Our Ref: LU/245/19/L

Application for Listed Building Consent for Alterations, Extension or Demolition of a Listed Building

Development Listed building consent for the replacement of single sash window to west elevation.

Location Friends Meeting House 23 Church Street Littlehampton

PROPOSED ELEVATIONS 1:100

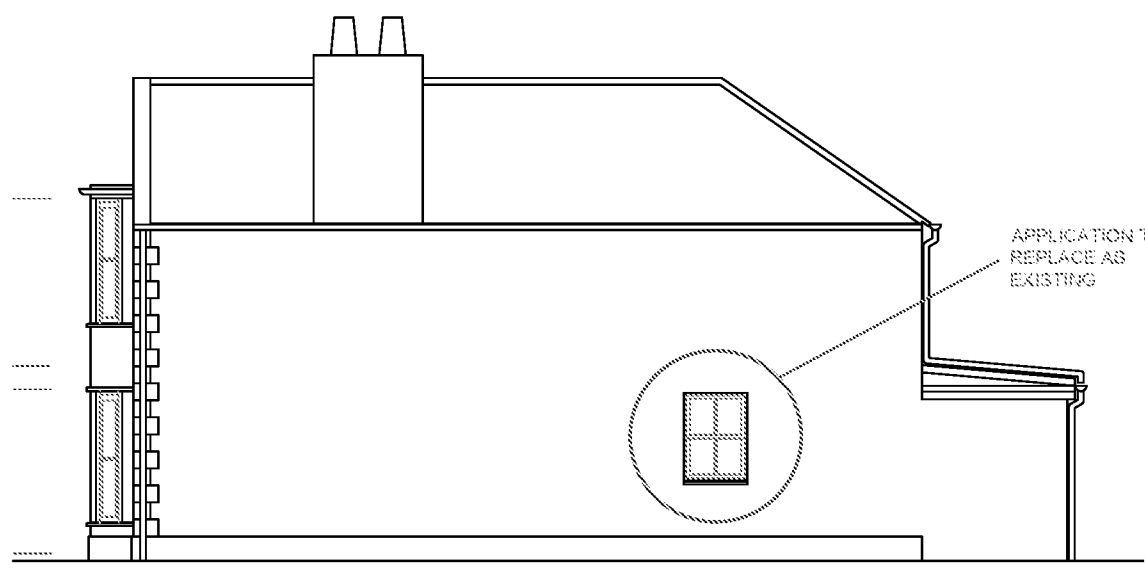
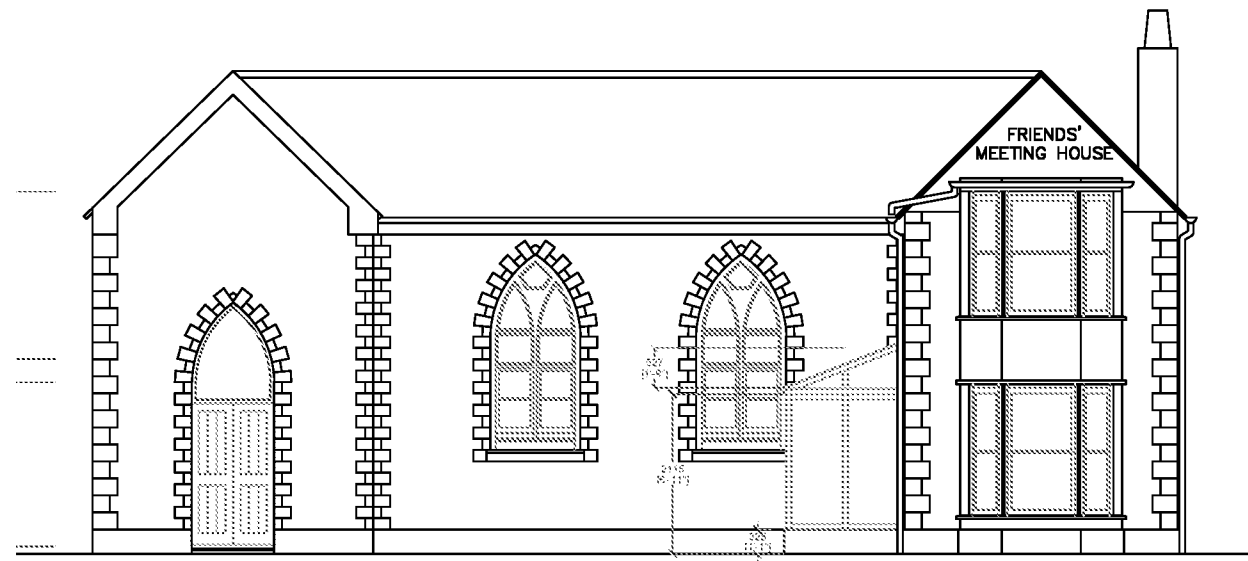
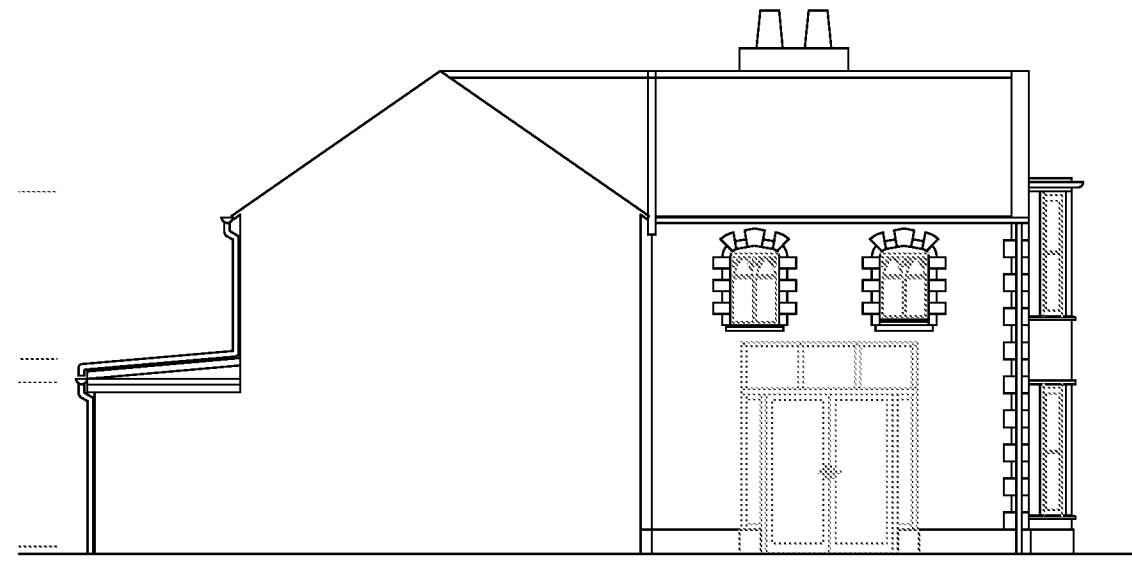
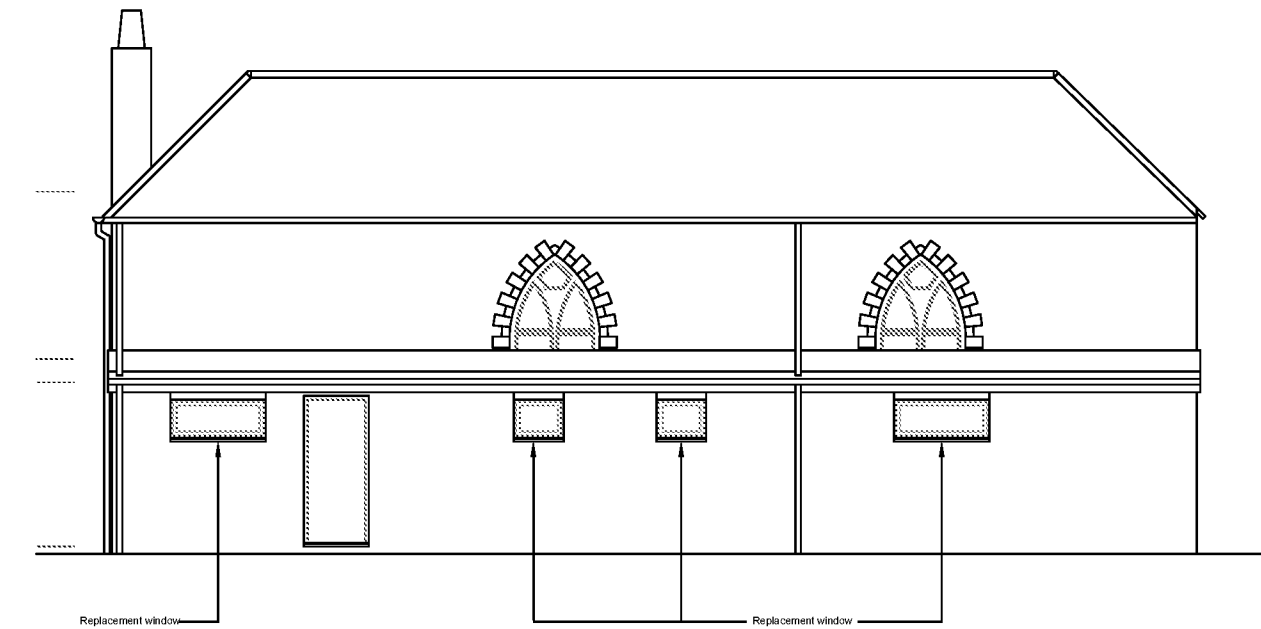
Two elevations have been labelled as west. Please amend accordingly.

Please confirm that the window to be replaced is on the west elevation.
